Your Ref: OWPC18975
Our Ref: EP/83/18/HH
Please ask for:
Mr Z Denton

27th June 2018

Replacement side extension
61 Roundstone Crescent East Preston

Project: Proposed extension; 61 Rounstone Crescent, East Preston BN16 1DQ	
Drawing: Plans and elevations as proposed	
For: Mr. & Mrs. D. Larkham	
Drawn: PKS	Date: April 2018
Scales: 1:100 1:200	No: 2279/01/02
To scale when printed on A3

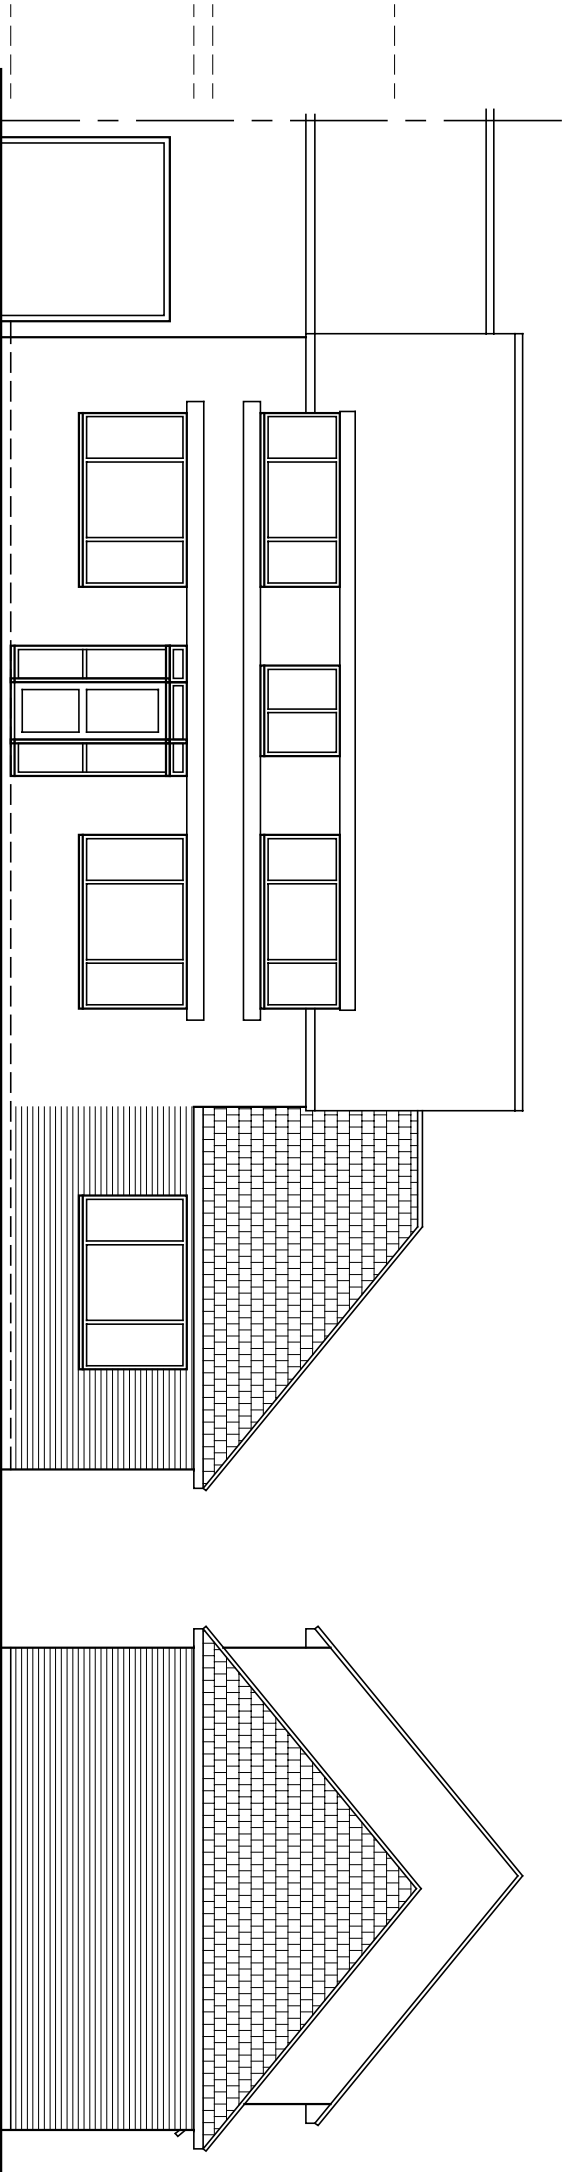
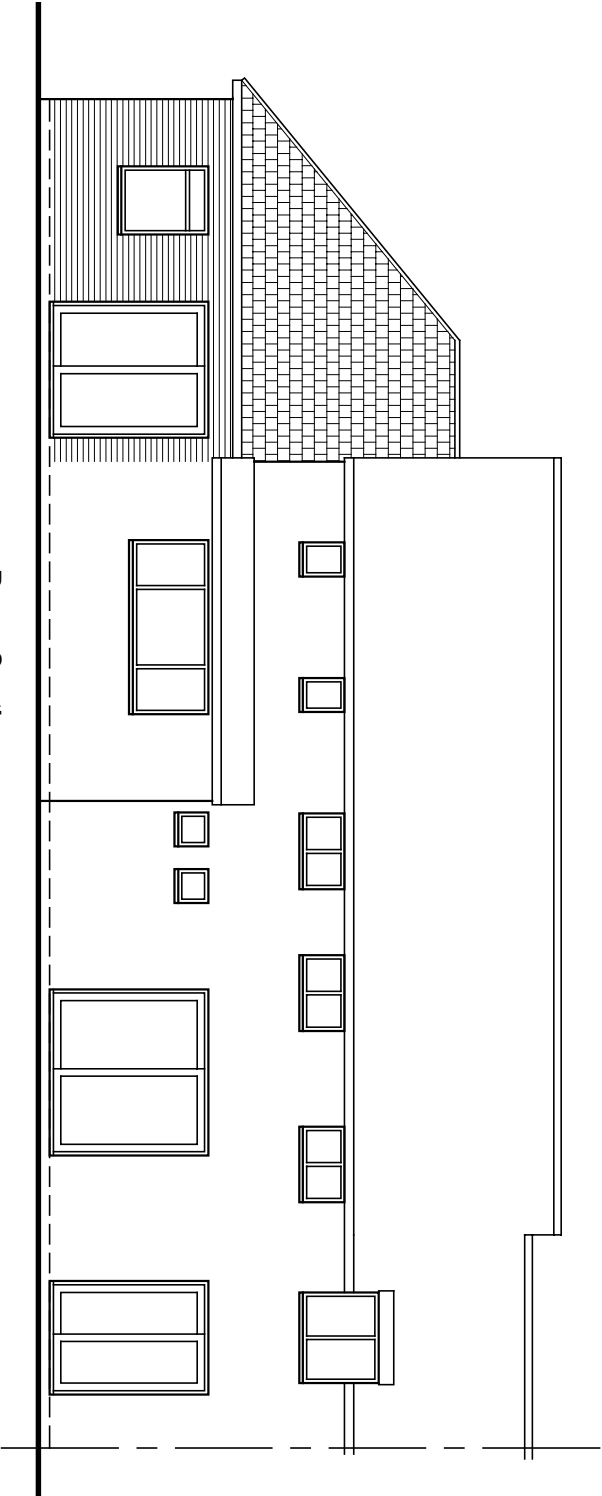
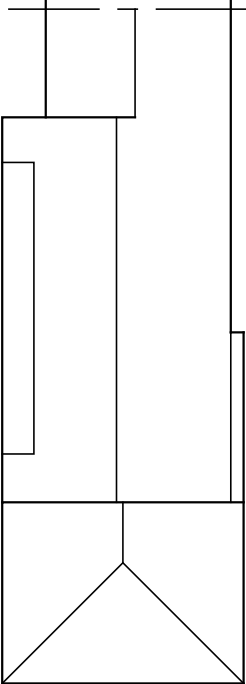
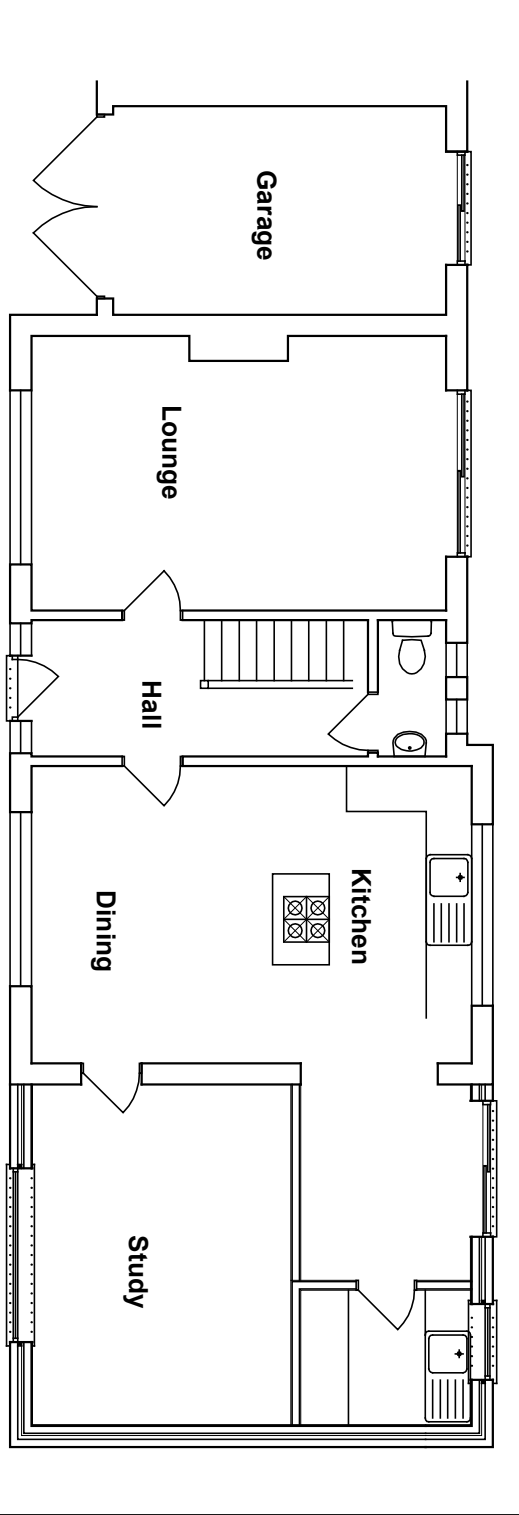
The committee agreed unanimously to object to this Application purely because of the poor design of the proposed roof as the committee deemed it was far too large for the proposed single storey extension. The committee felt this was poor design and therefore contrary to the National Planning Policy Framework alongside more local policies. Section 64 of the NPPF says, "Permission should be refused for development of poor design...". The committee had no concerns about the addition of the single-storey extension, just the design of the roof.
